**From:** Build View [REDACTED]  
**Sent:** 12 November 2021 14:16  
**To:** Kathryn Welch  
**Subject:** Re: R/222/21/HH - REP Letters  
**Attachments:** 42 Pigeon House Existing and Proposed LPA Rev3.pdf

**From:** [REDACTED]  
**Date:** Thursday, 28 October 2021 at 14:28  
**To:** kathryn.welch@arun.gov.uk <kathryn.welch@arun.gov.uk>  
**Subject:** R/222/21/HH - REP Letters

04

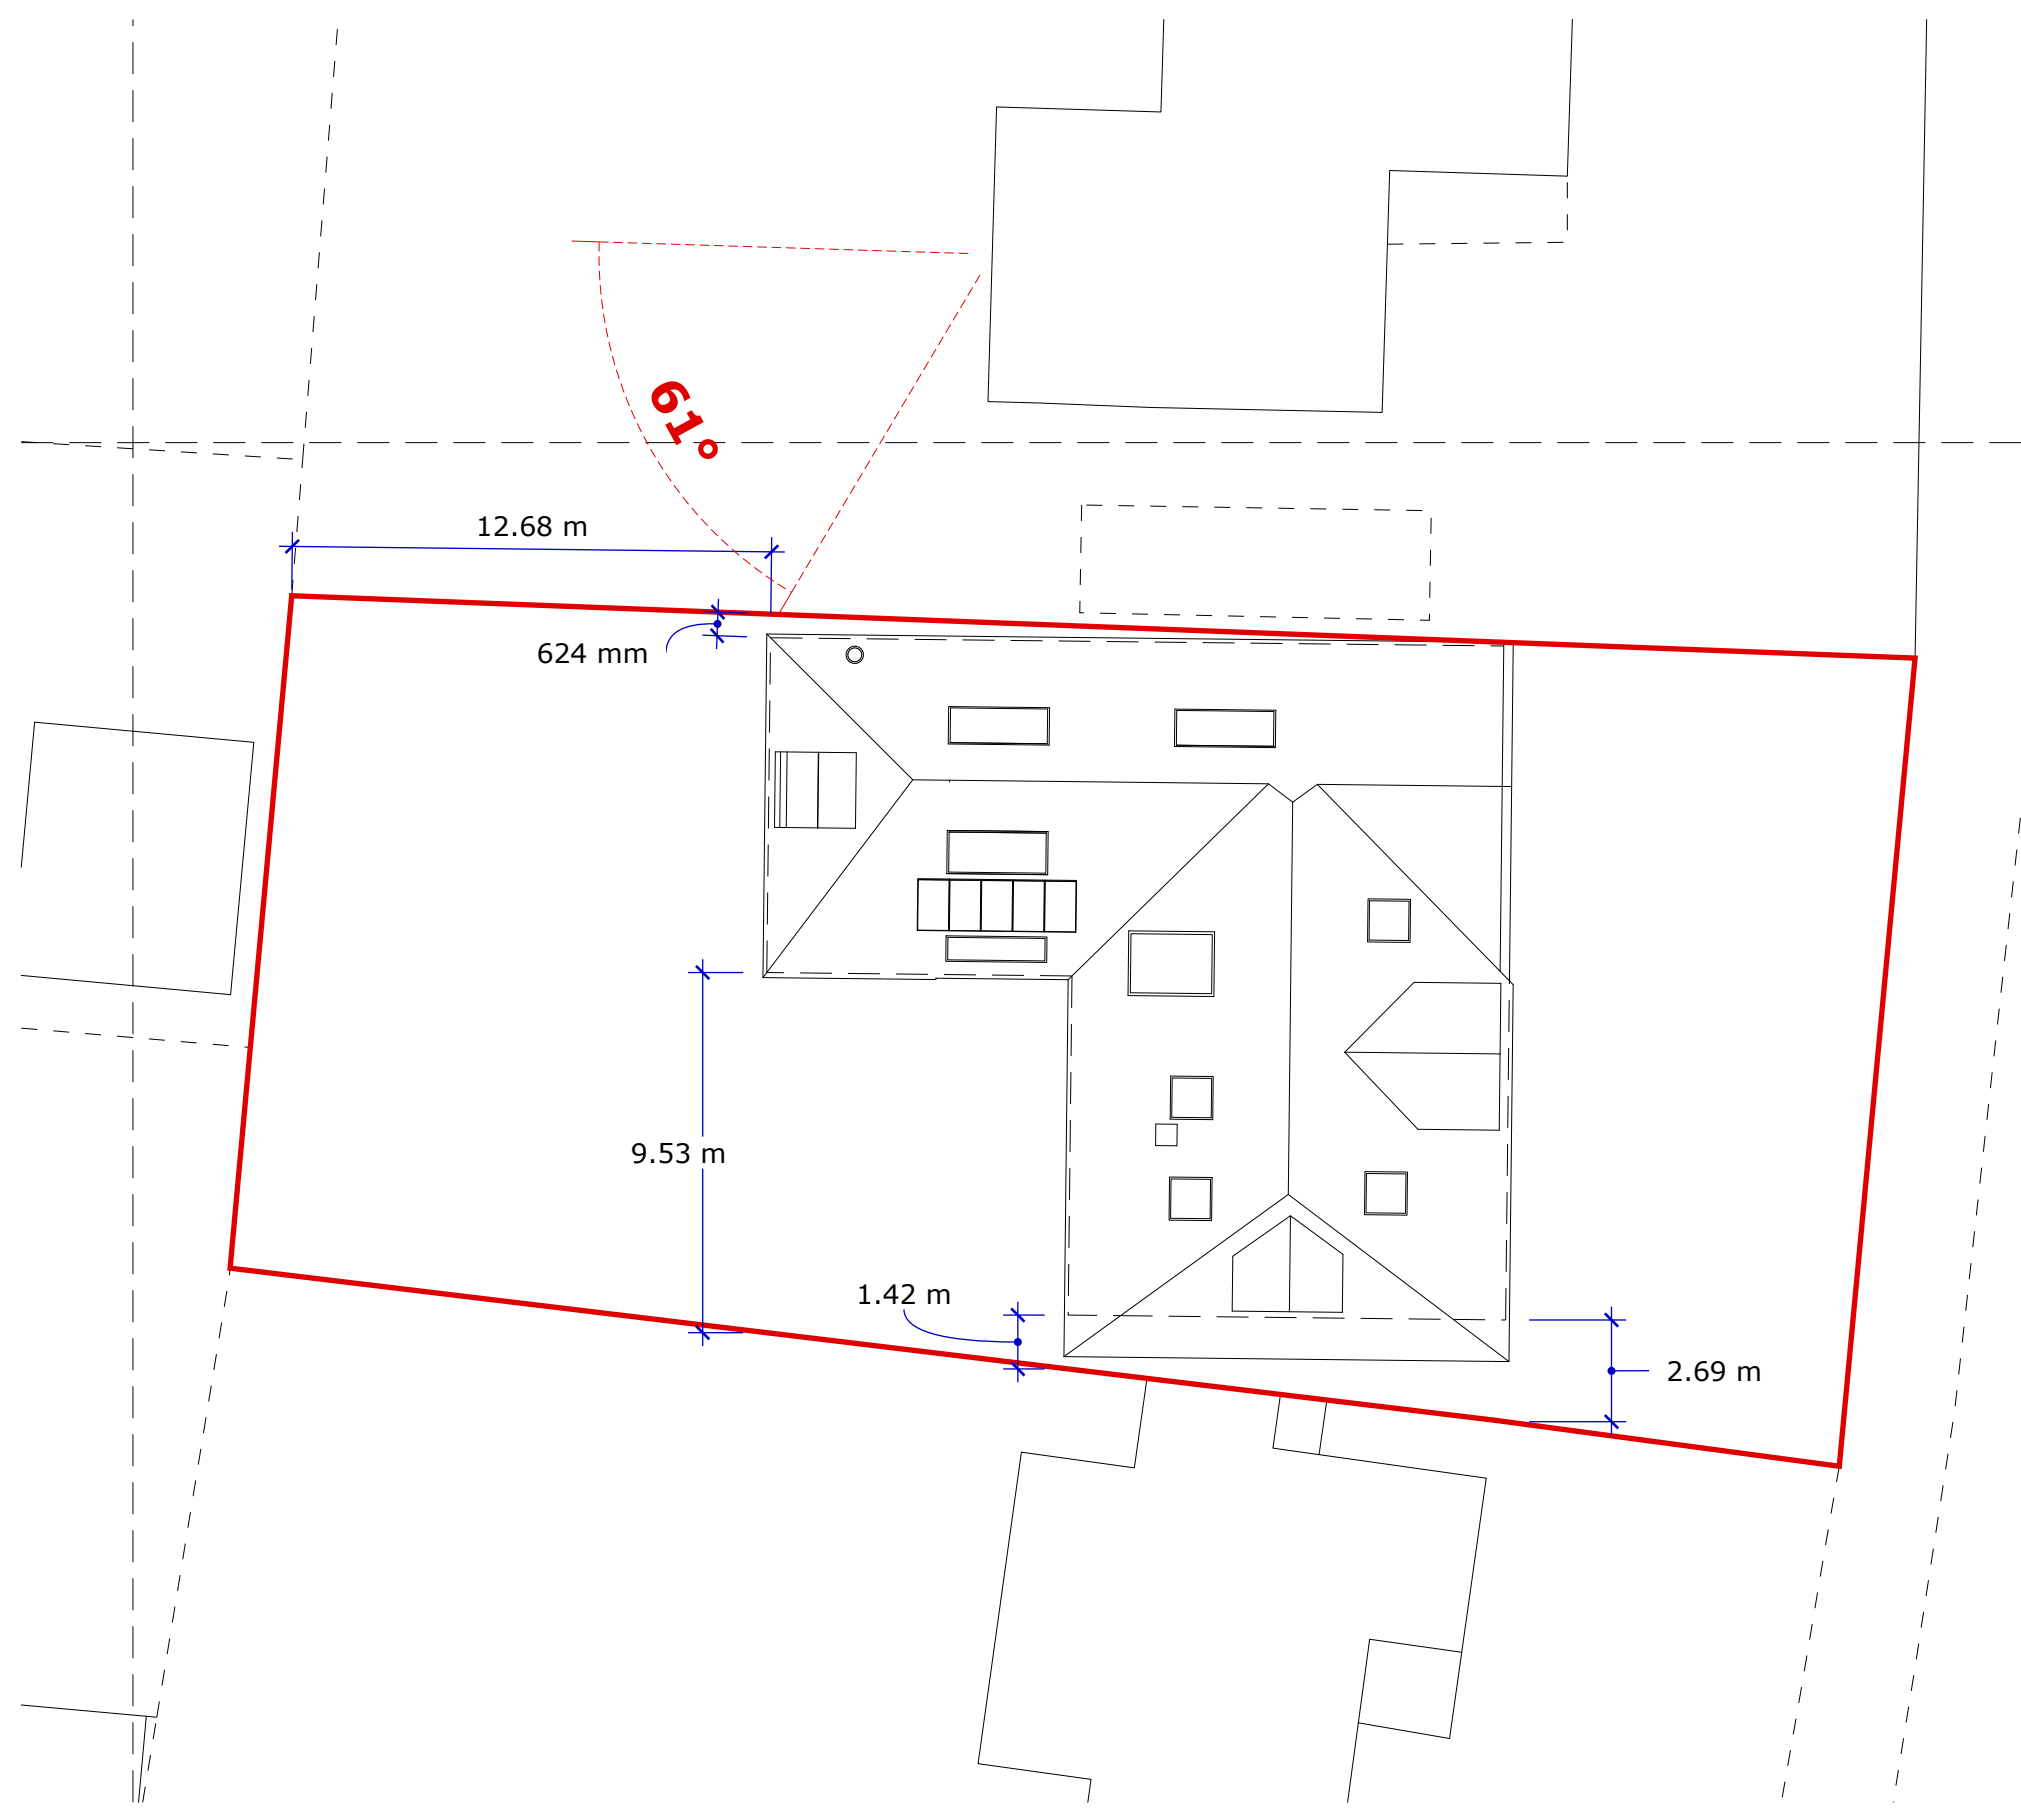
This dormer has been presented with non-openable glazing below 1700mm and is presented with obscured glass. There is no loss of privacy and or the chance of any overlooking which may be considered unneighbourly. The opposing dormer also has obscure glazing.

- 1, The boundary has been taken from the ordinance survey maps, OSGrid Ref: TQ 610 172.
- 2, All Windows to the North are Velux type windows 1700mm from the FFL and as such do not present any overlooking issues and are permissible under PD. The proposed balcony is recessed within the roof structure with the glazed balustrade within the hip of the roof, thus making any attempt to overlook physically impossible.
- 3, As understood by the case officer during the pre-application phase, care has been taken during the design considering any adverse effect on the neighbours. The pre app ref: PAA/92/21/
- 4, The out door kitchen chimney has notionally been included, this is for BBQ's during the summer only and has been included to REDUCE any ad hoc smoke effect on any neighbour as and when my client has BBQ's.

All roof lights are Velux roof windows and as such would fall under PD. The glazed eastern window over the stairs is non openable. The balcony and glazing has been acknowledged within the pre application received.
